From: Laura Gibbons
Sent: 08 May 2018 13:14
To: Planning.Responses
Subject: RE: Planning Consultation on: AL/44/18/RES

Engineers comments in respect to surface water drainage:

APPLICATION AL/44/18/RES

Site Address: Oldlands Farm Steyning Way Bersted PO22 9NW

DRAINAGE STRATEGY

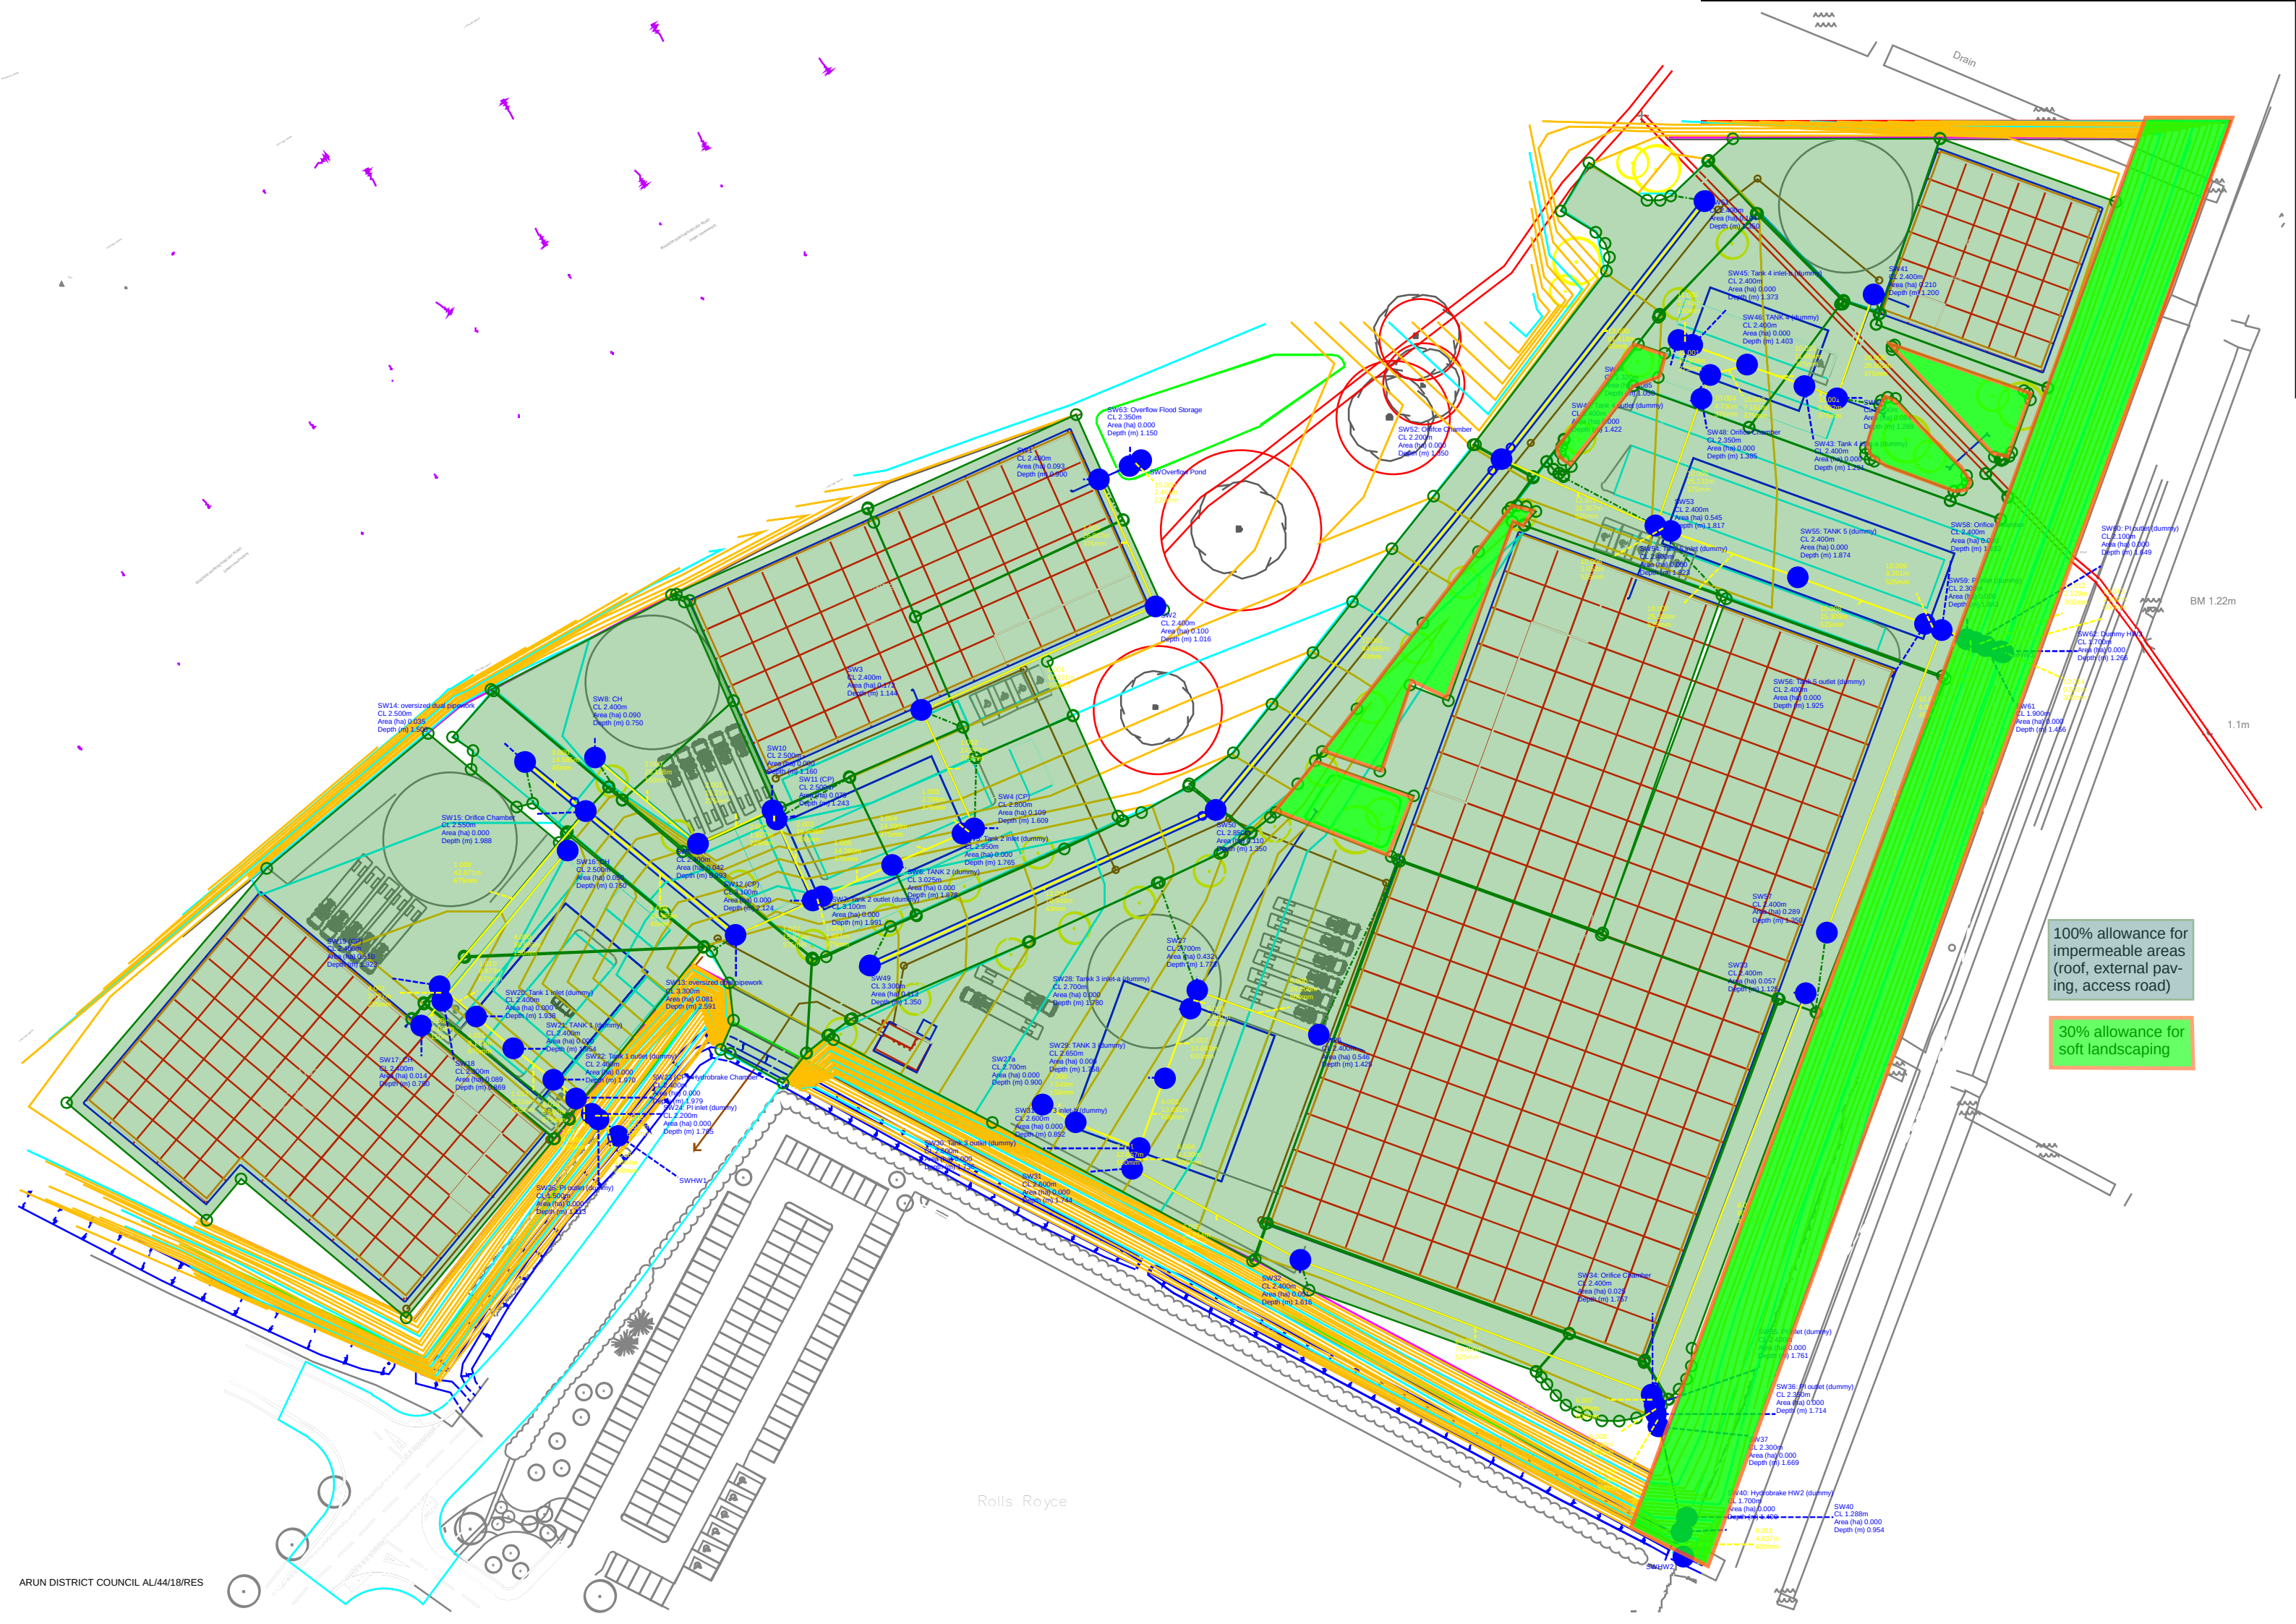
- Is the ditch running to the east of the site proposed or existing? If it is existing, clearance and de-siltation will be required. If it is proposed, consent will be required, and network rail will need to be consulted with.

- Any culverting, alteration or proposed new ordinary watercourses will require land drainage consent from ourselves.
- The proposals appear to be abandoning numerous sections of ditch. Consent has not been gained to date, as far as I am aware. We will need to discuss this further, and if found to be acceptable, adequate compensation will be required due to the loss of storage/habitat. These ditches generally fill up from the backwater effects from Lidsey Rife/ Aldingbourne Rife, so it is very important that no storage is lost.

- Proposed surface water outfalls will require a minimum of 300mm between bed of watercourse and pipe outlet. Headwall details will need to be agreed.
- Has compensatory flood plain storage been agreed with the Environment Agency? Natural England would like to be consulted regarding this and the potential to incorporate habitat.
